Subject: Ref 2023/91907 - residential development, rear of 18 Kingsley Avenue, Lockwood

Network Rail Consultation Response

FAO:	Katie Chew
Date:	4 August 2023
Application reference:	2023/91907
Proposal:	Demolition of dwelling to create access and erection of 10 dwellings
Location:	Rear of 18 Kingsley Avenue, Lockwood, Huddersfield, HD1 3SR

Description **SITE LOCATION PLAN**

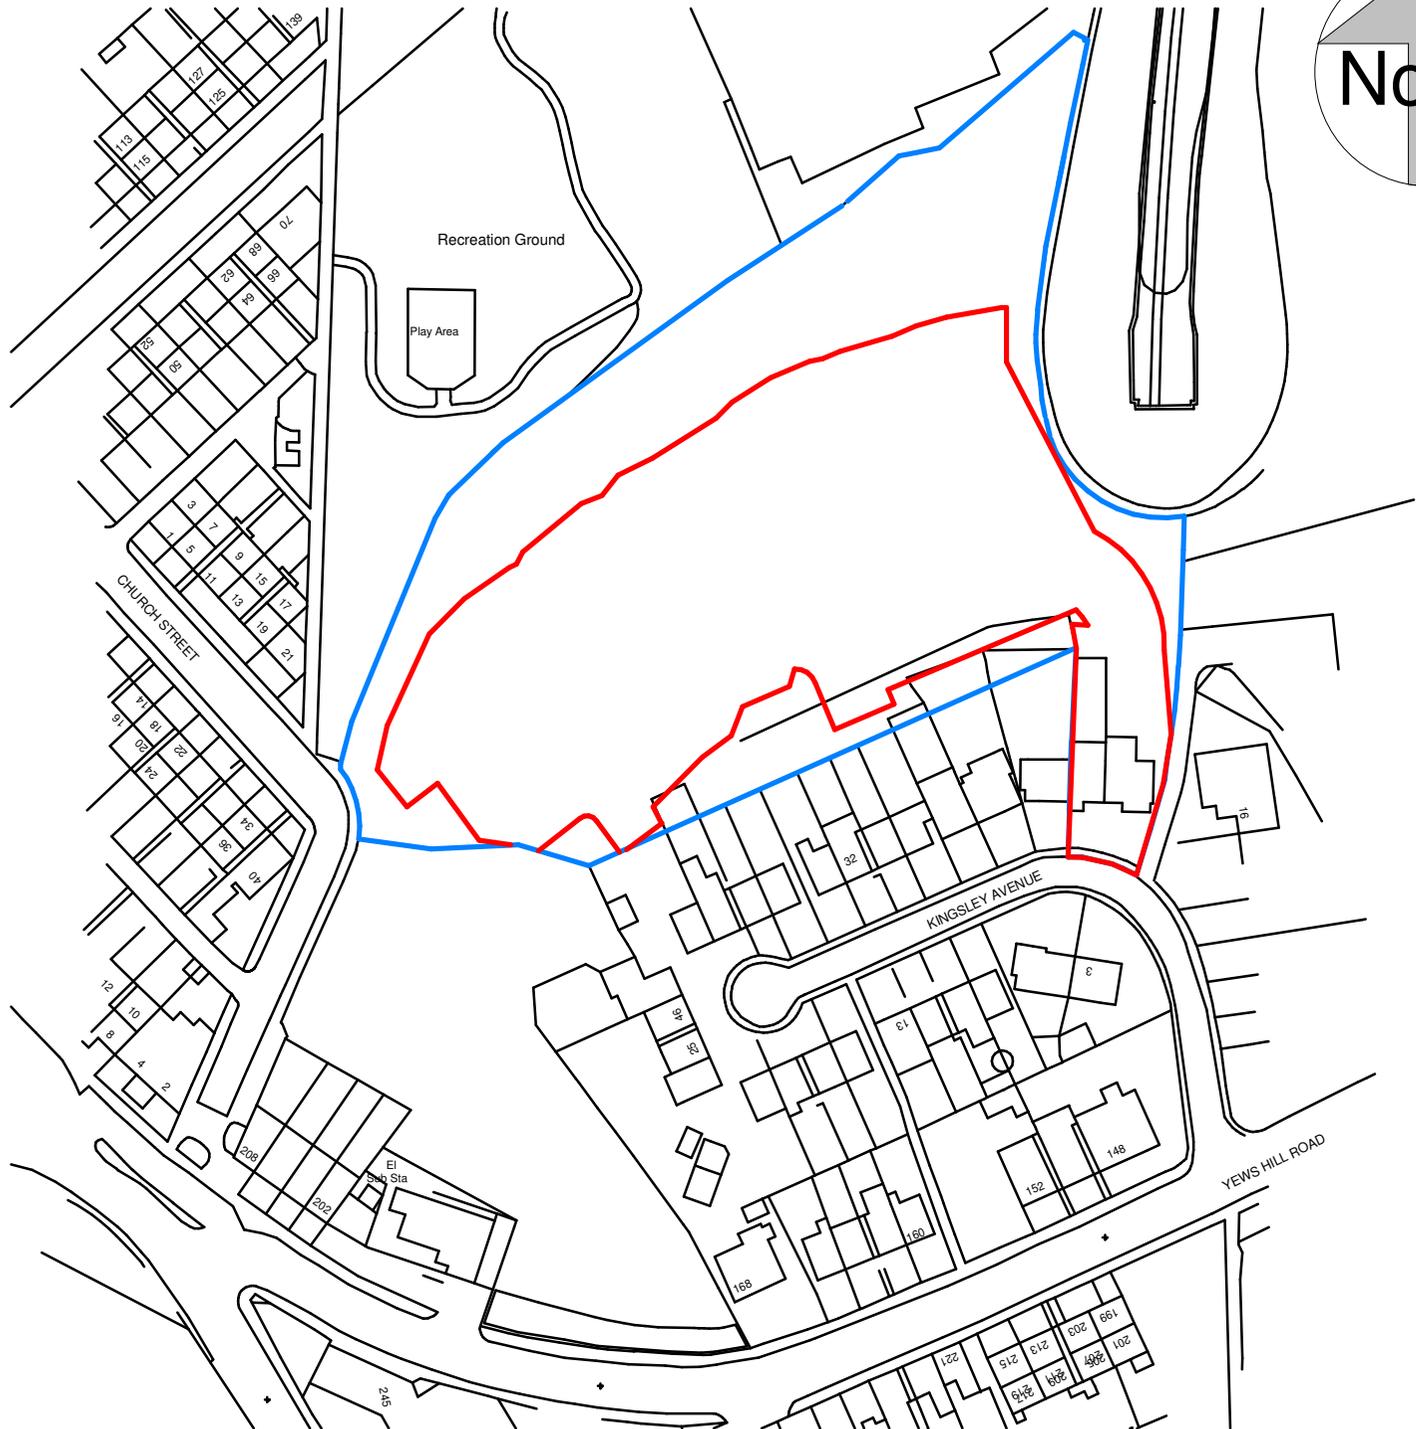
In addition, we are unable to support the proposals in their current format as the development as proposed appears to be partly located on an area of land still in the ownership of Network Rail over the railway tunnel. The attached plan shows the land in Network Rail's ownership (shaded green).

It is therefore appropriate that the applicant re-submit the redline plan showing the correct boundary or contact Network Rail at landinformation@networkrail.co.uk to discuss the boundary issue and reach agreement.
